# KITTITAS COUNTY COMMUNITY DEVELOPMENT SERVICES

August 31, 2023

## **RE: CU-23-00002 The Outpost – Deemed Incomplete and Request for Additional Information**

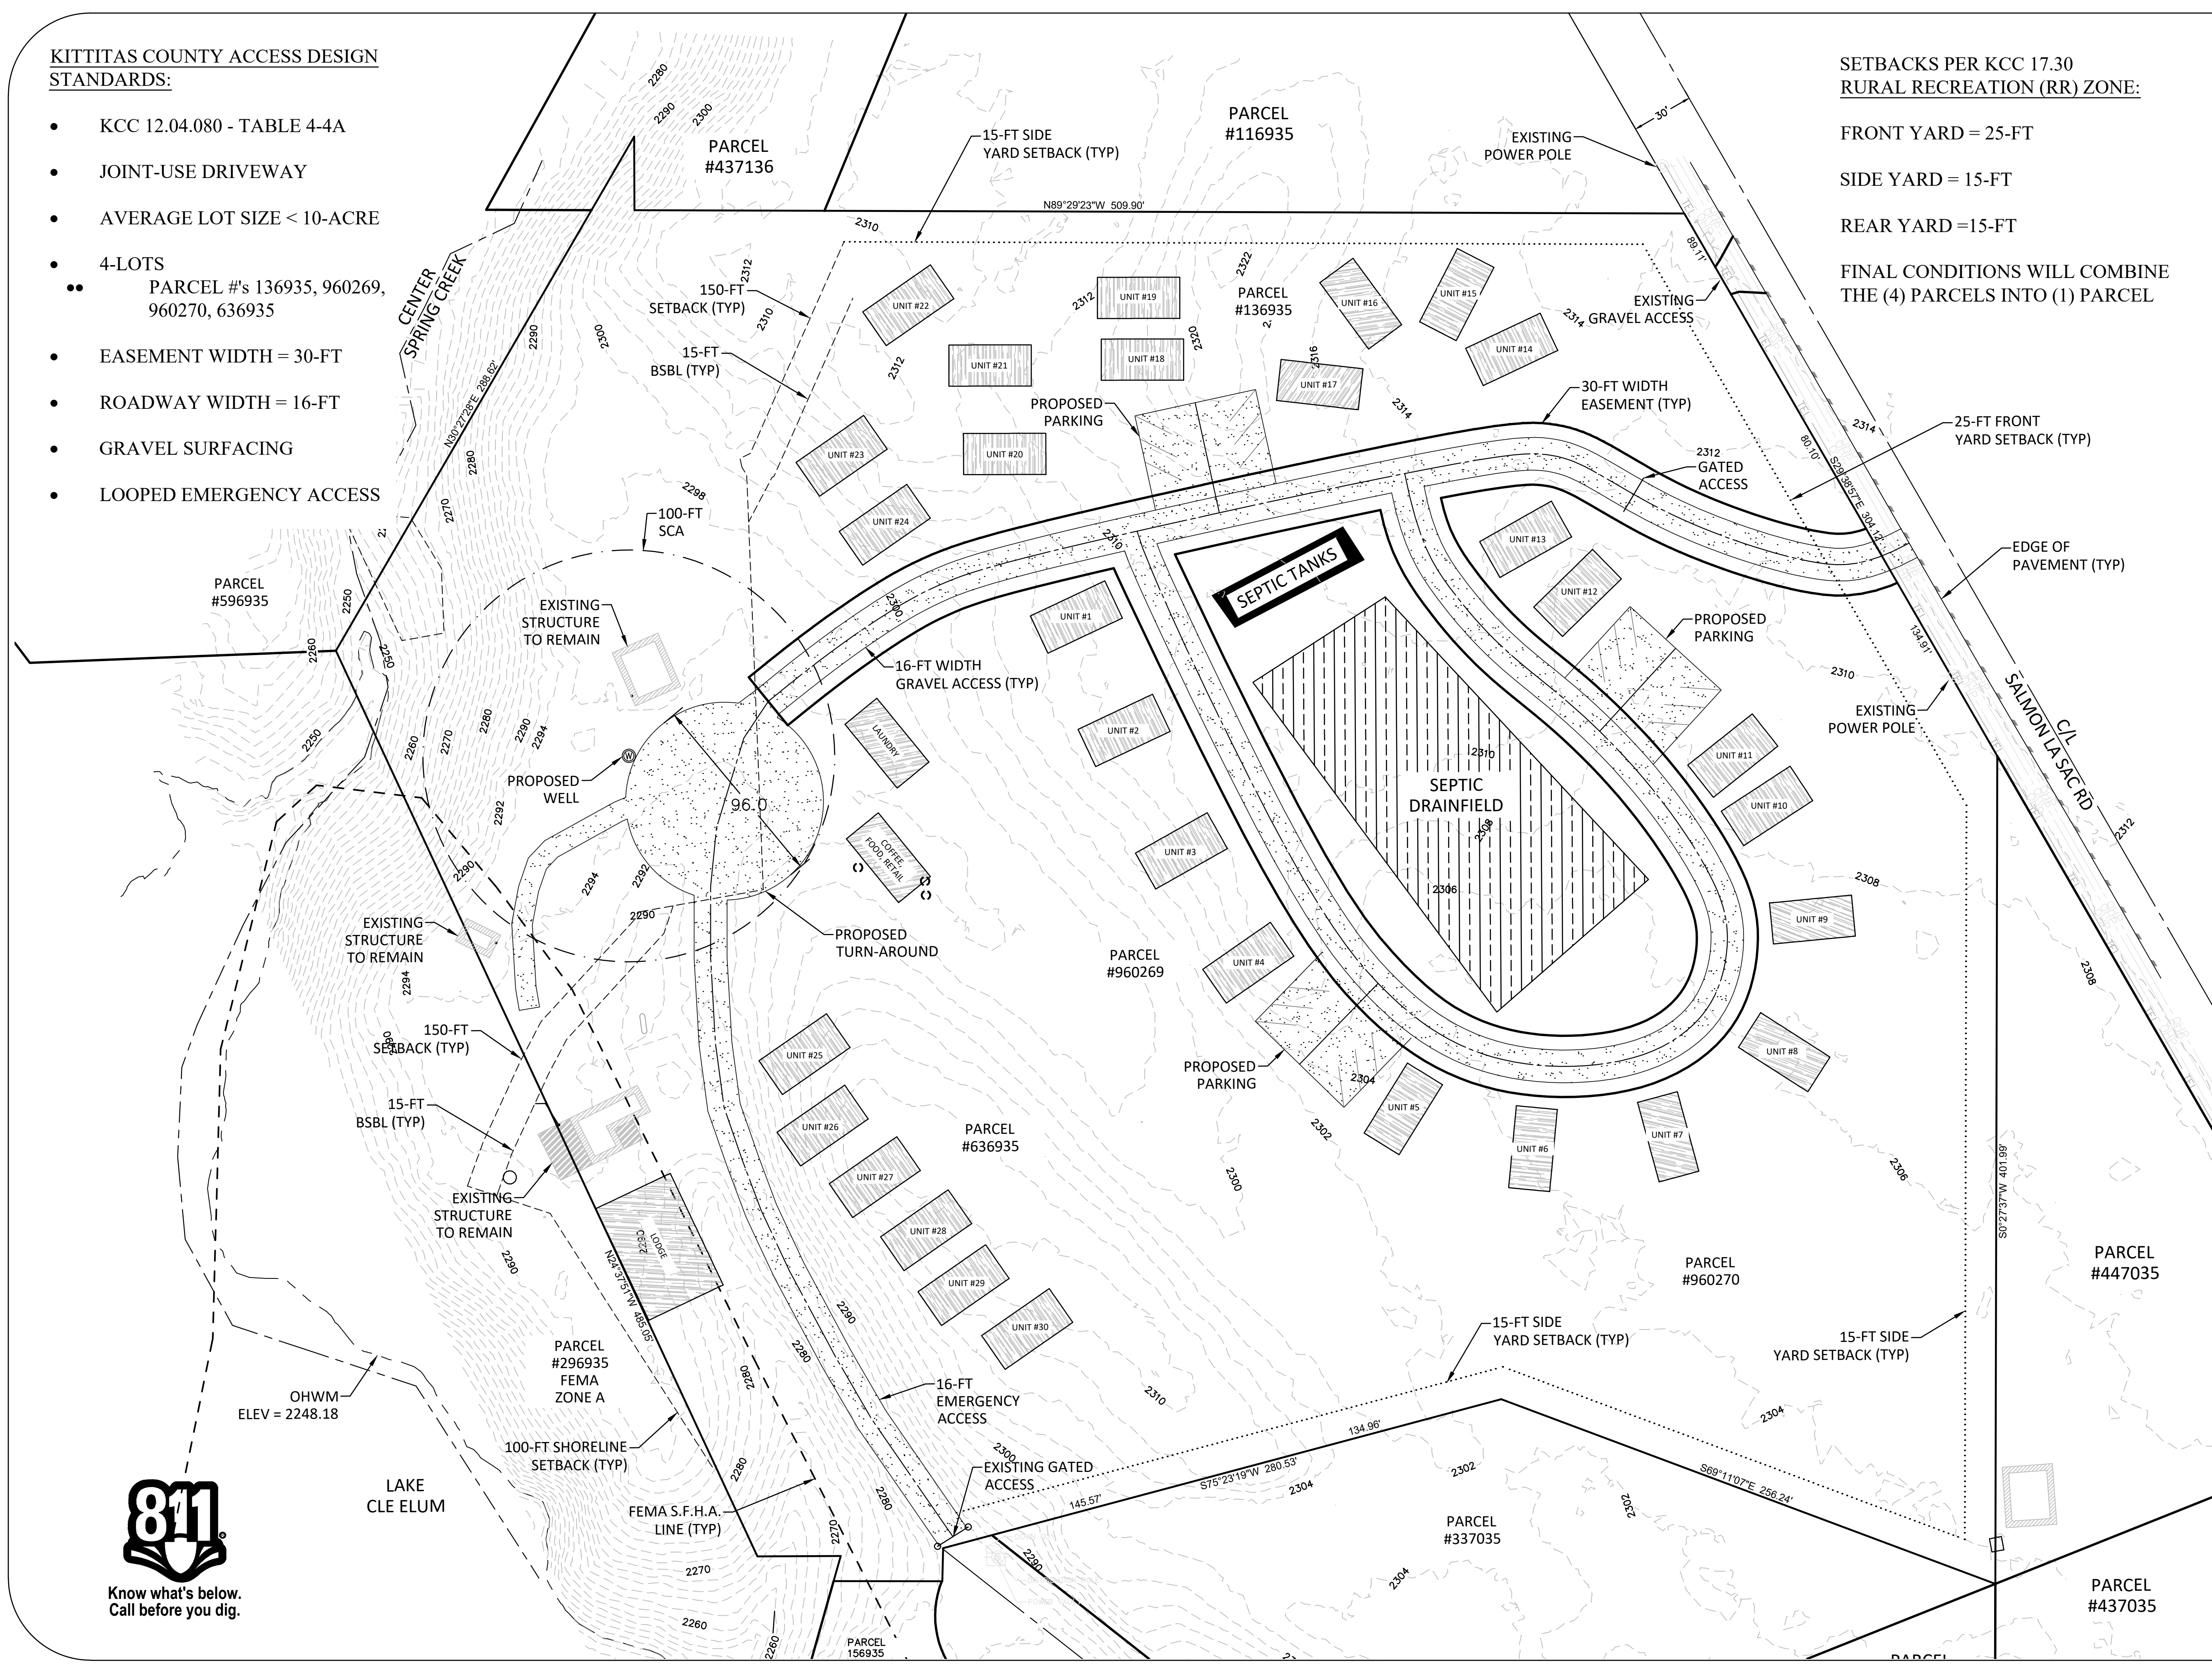
- 1) Shoreline Substantial Development Permit
  - a) The updated site plan shows development occurring within shoreline jurisdiction. Development within shoreline jurisdiction is subject to the provisions of Title 17B of Kittitas County Code. As such, the proposed project will require a Shoreline Substantial Development Permit to be approved prior to further processing of your Conditional Use application.

- 2) Additionally, in relation to KCC 17A – Critical Areas, the updated site plan shows development occurring within established critical areas buffers (proposed well, proposed turnaround/roadway, etc.). The site plan must be updated to meet the standards of KCC 17A – Critical Areas.

- 3) The updated site plan shows a lodge being proposed within the property line setback. The lodge needs to either be sited outside of the property line setback or a Zoning Variance will need to be granted for a reduced setback.

- 4) The updated site plan indicates “FINAL CONDITIONS WILL COMBINE THE (4) PARCELS INTO (1) PARCEL”. To combine the subject parcels, you will need to complete a Parcel Combination application.
